SICEEP, South West Plot (SSD6011) – Response to Transport for NSW

PROJECT NUMBER	DRAWING NUMBER	REV
AA004399	SKCPD095	07

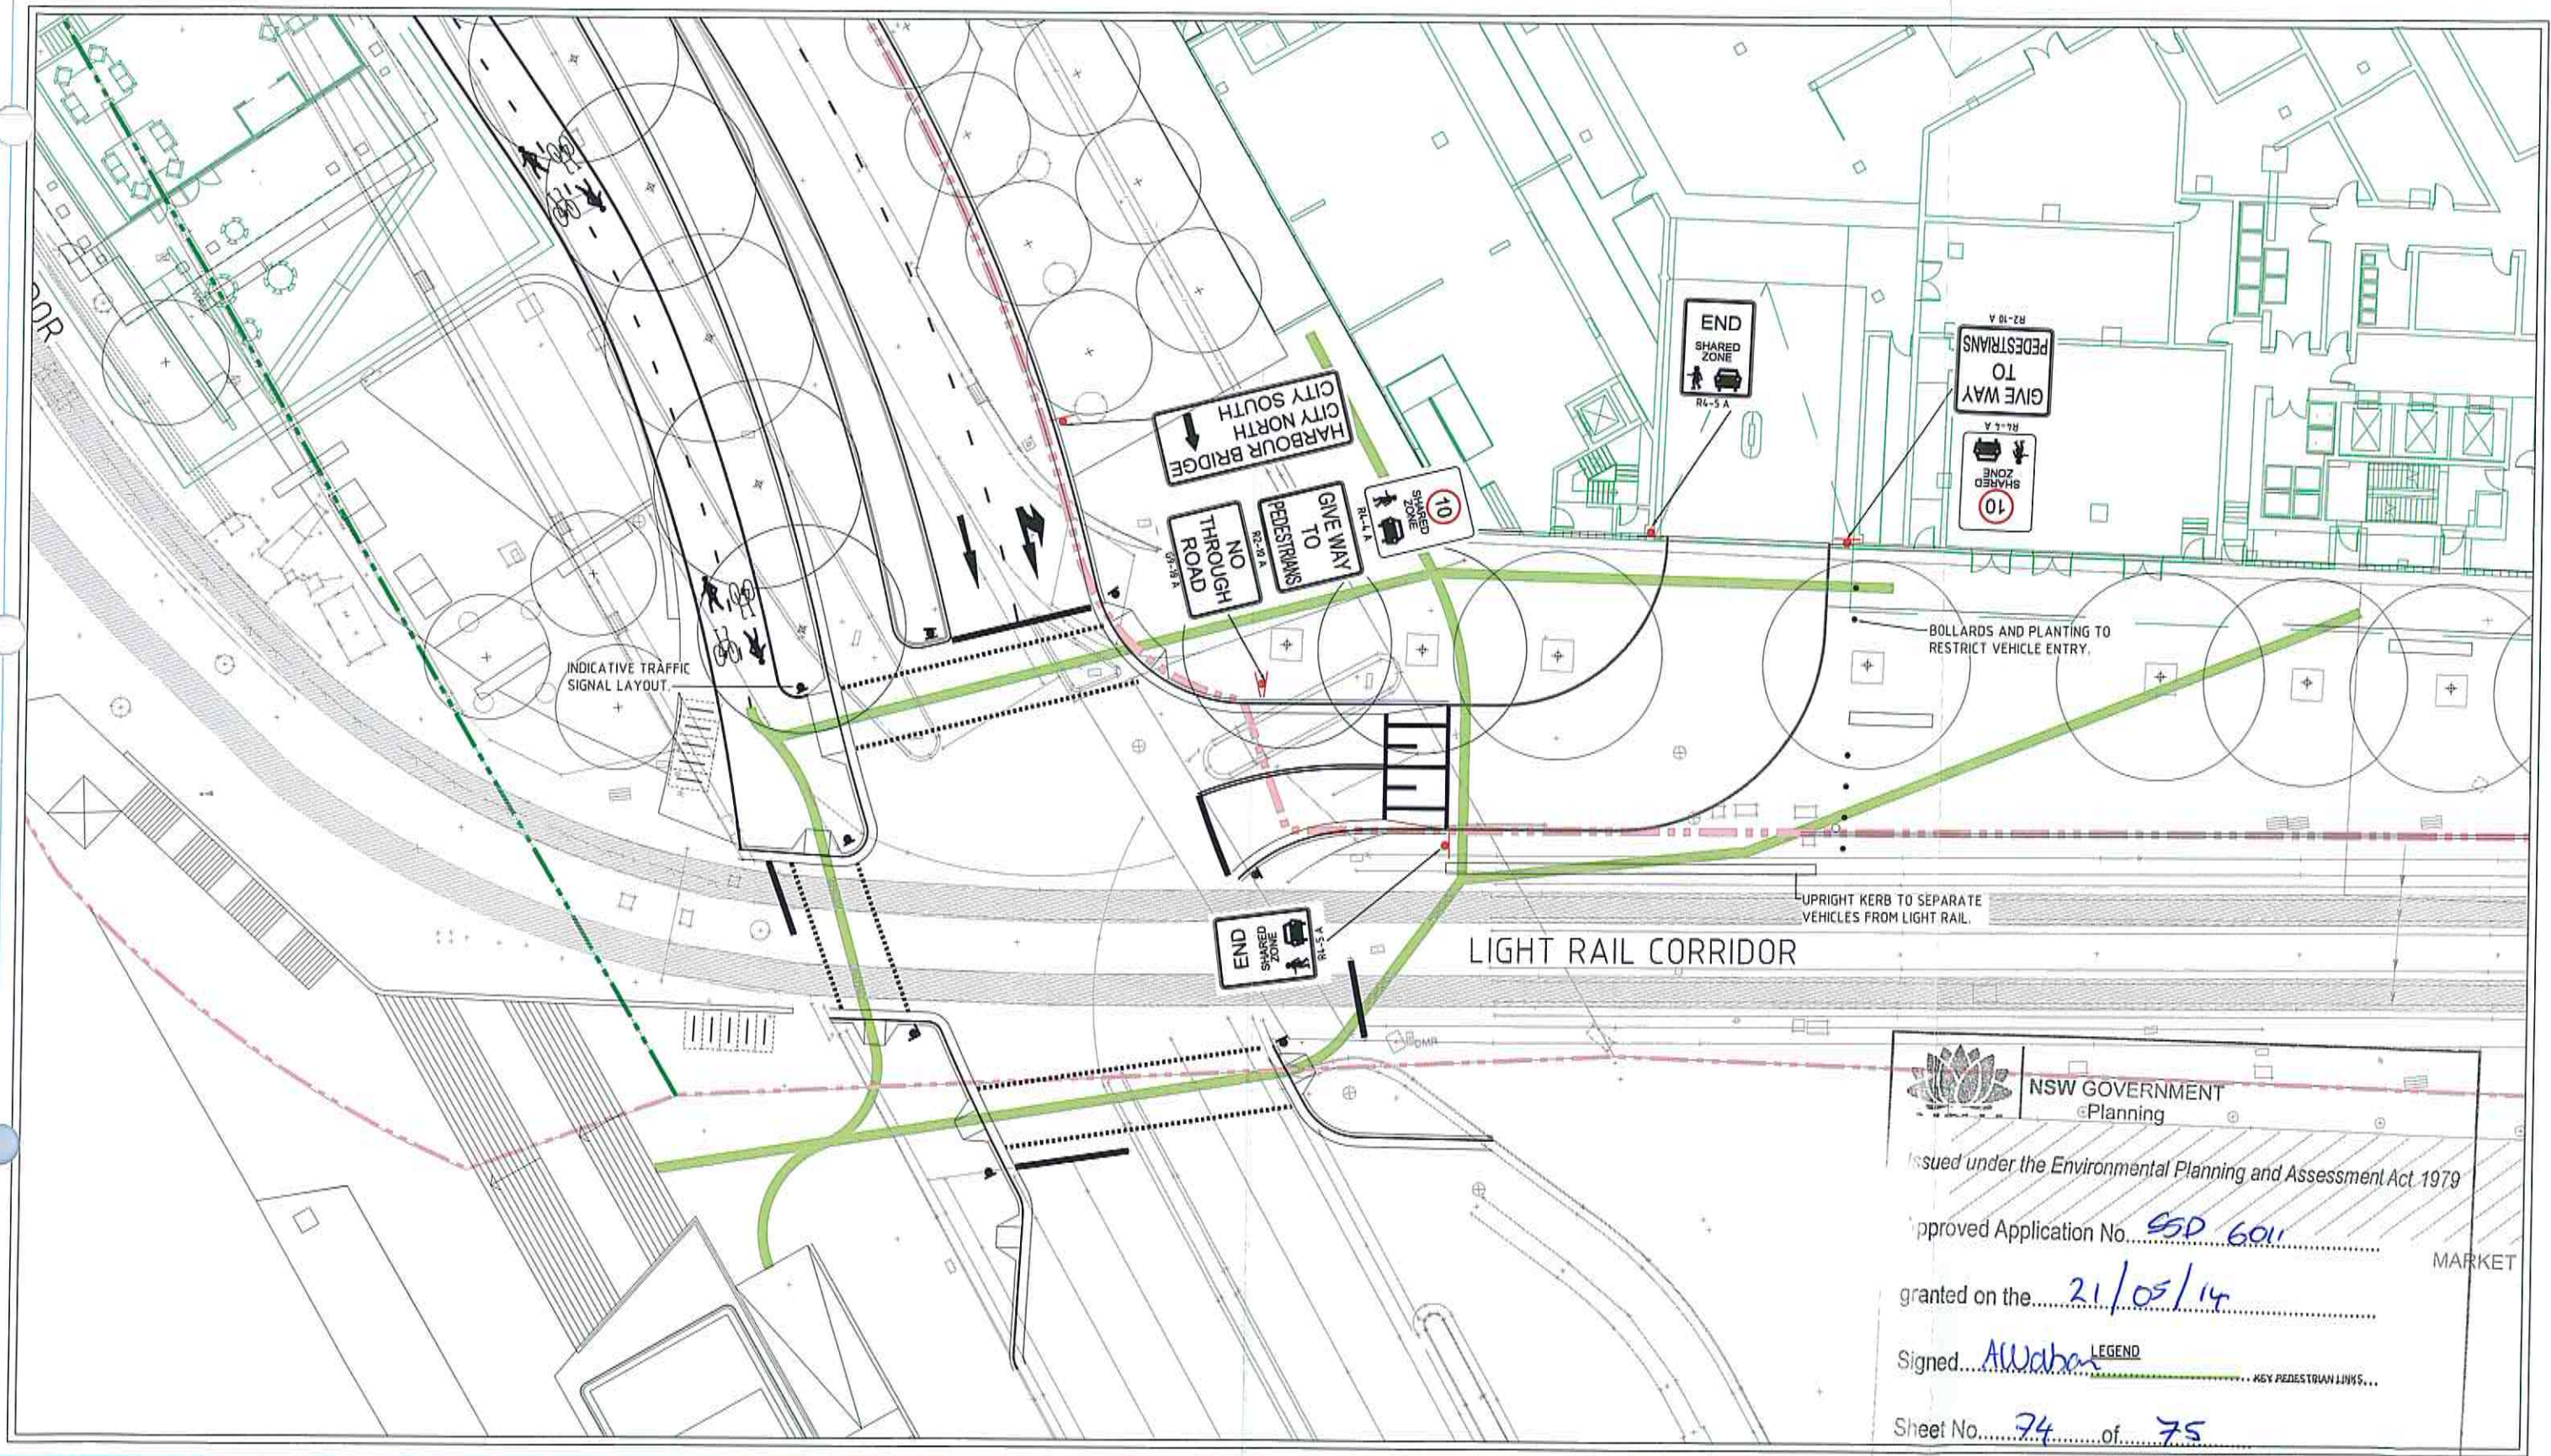
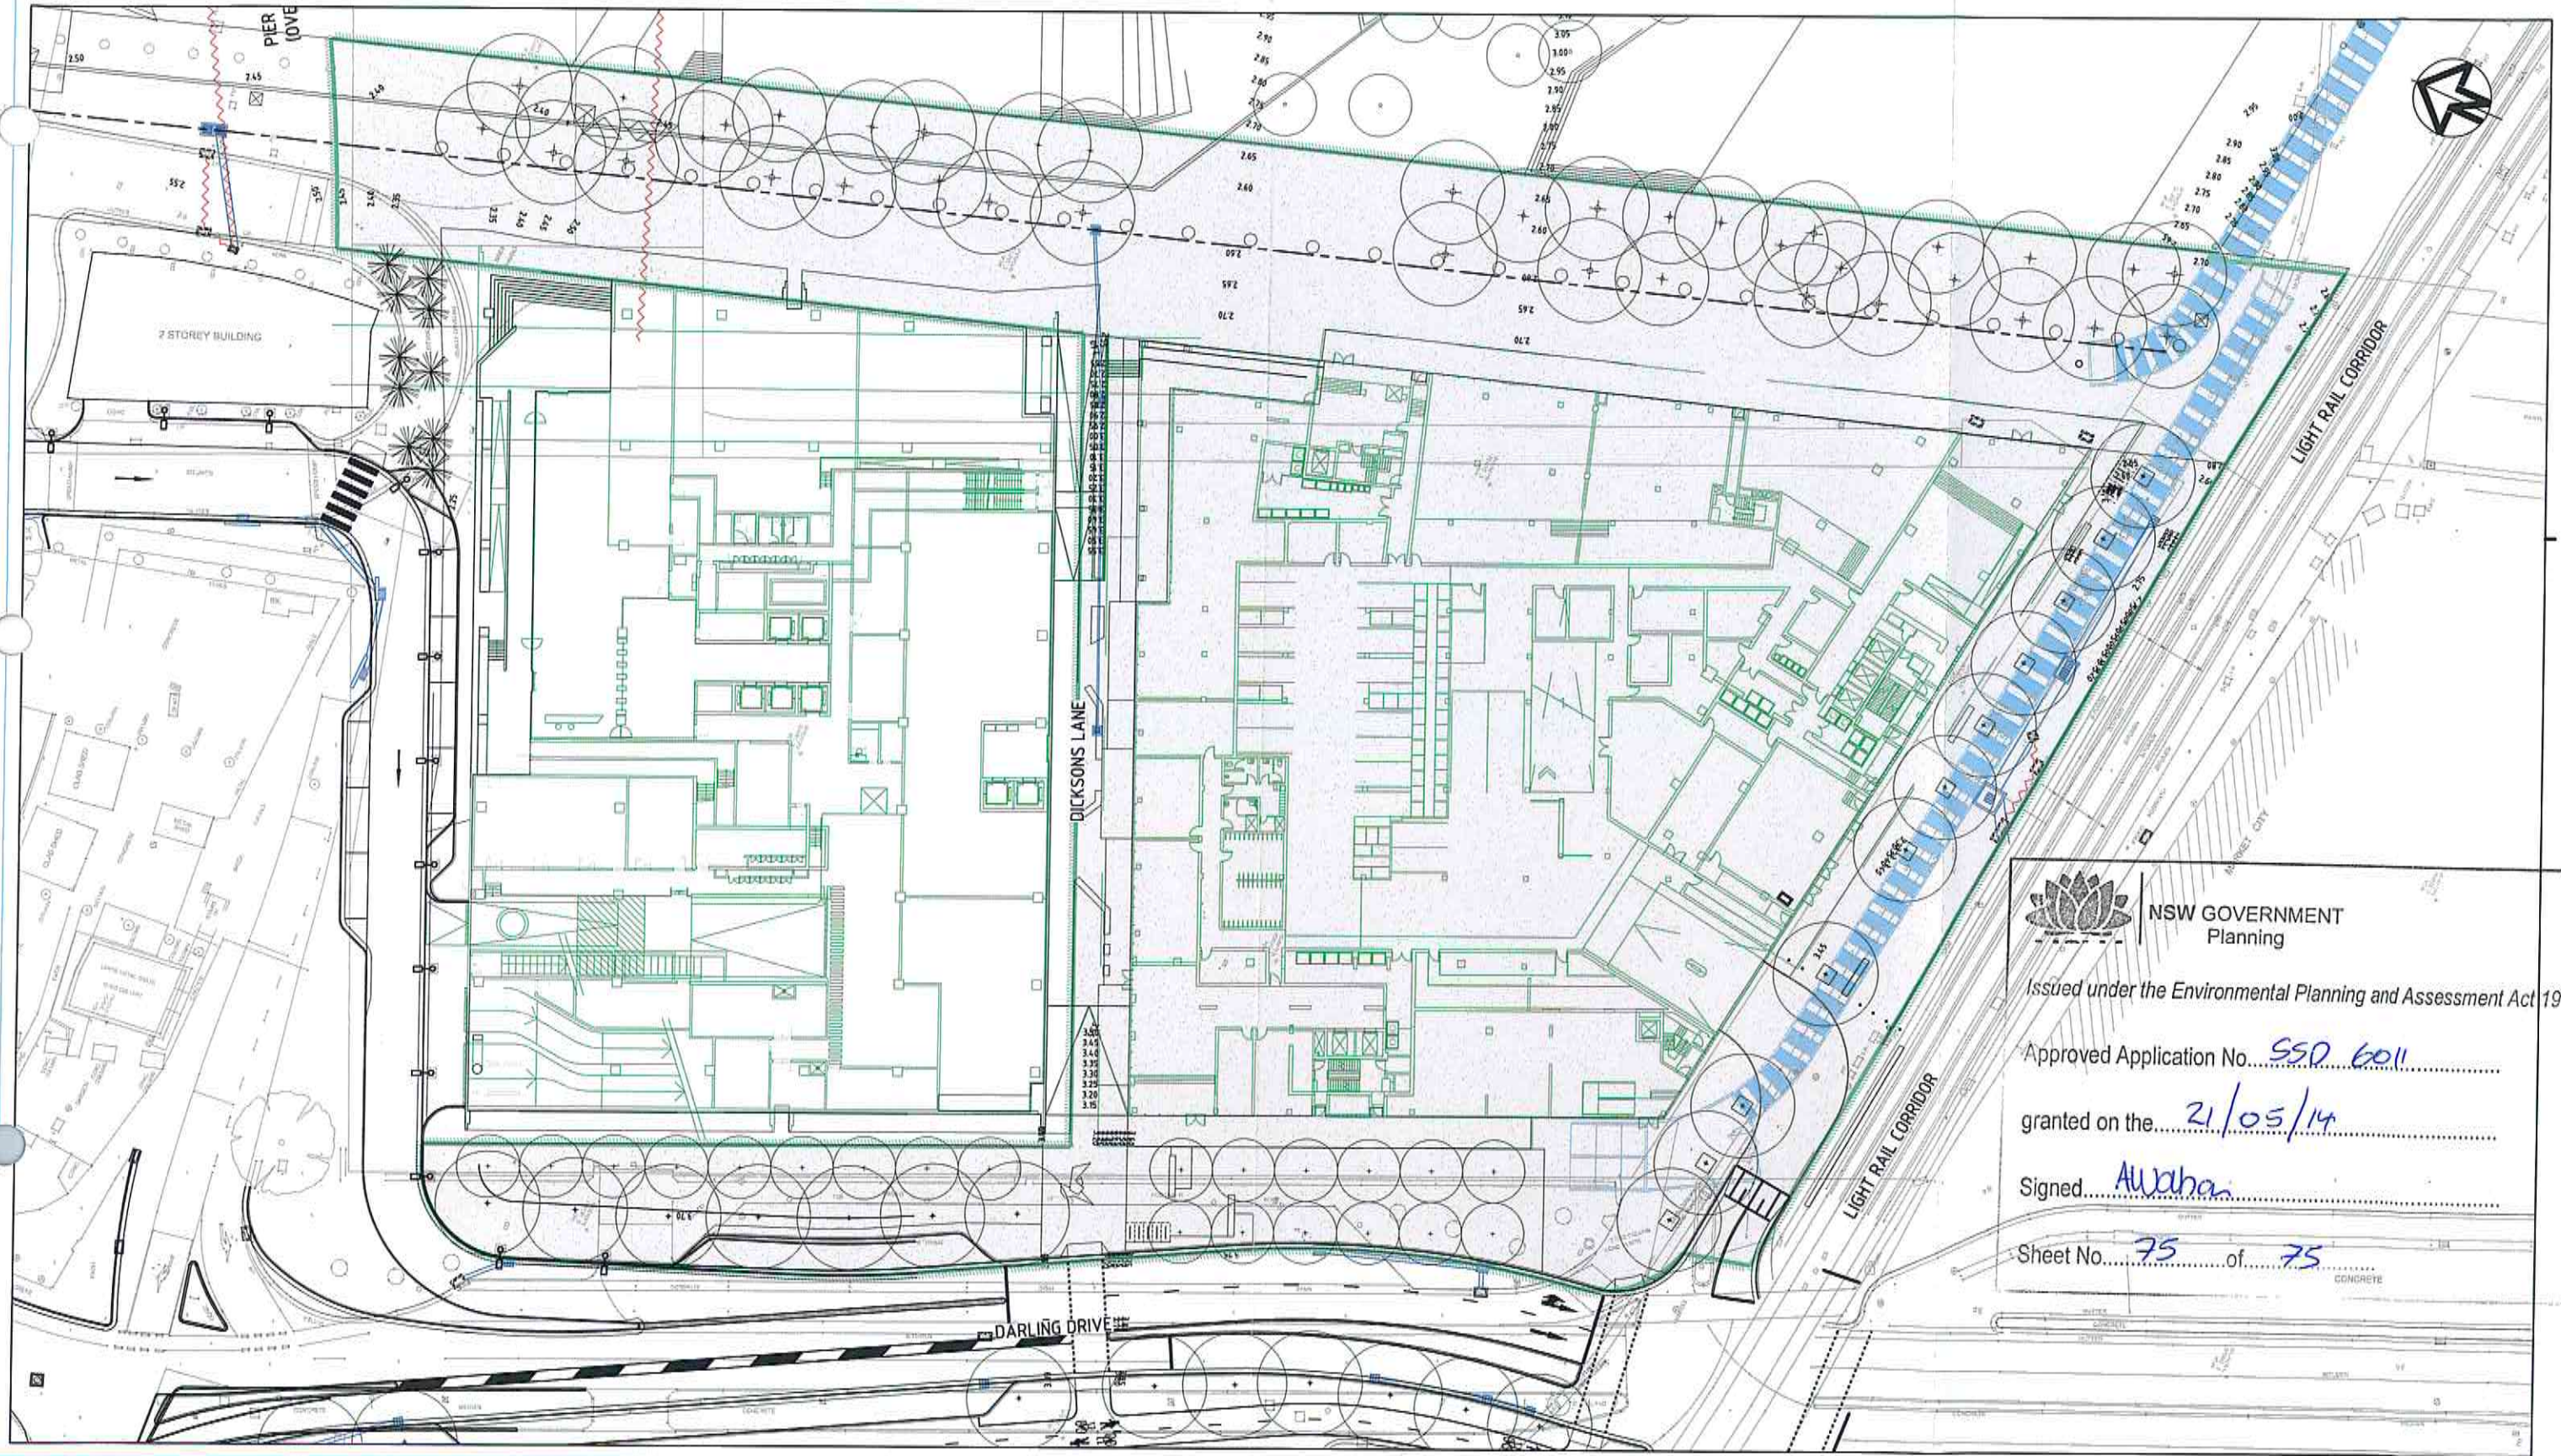
Condition C4	Amend to reference the Australian Standard not specifically Appendix D which isn't applicable to queuing. .
Condition C5	Condition acceptable.
Car Parking	
Condition C6	Condition acceptable.
Condition C7	Condition acceptable.
Traffic Signal Works	
Condition C8	Disagree, this is within SSDA3.
Condition C9	<p>Disagree</p> <p>There is provision under the RMS Traffic Signal Design (Section 2) which provides exceptions to the need for marked foot crossings if there is a parallel grade separated pedestrian facility provided, such as what is provided by the shared zone throughout Hay Street.</p> <p>Hay street is a shared zone throughout with the exception being the set down zone at the traffic signals at the intersection of Darling Drive and Hay. Desire lines for pedestrians moving north from the southern side of Hay will do not require the proposed traffic signals as demonstrated by the below diagrams/studies from the response to submission.</p> <p>Refer Drawing SKCPD095 from Hyder's Response to submission</p>
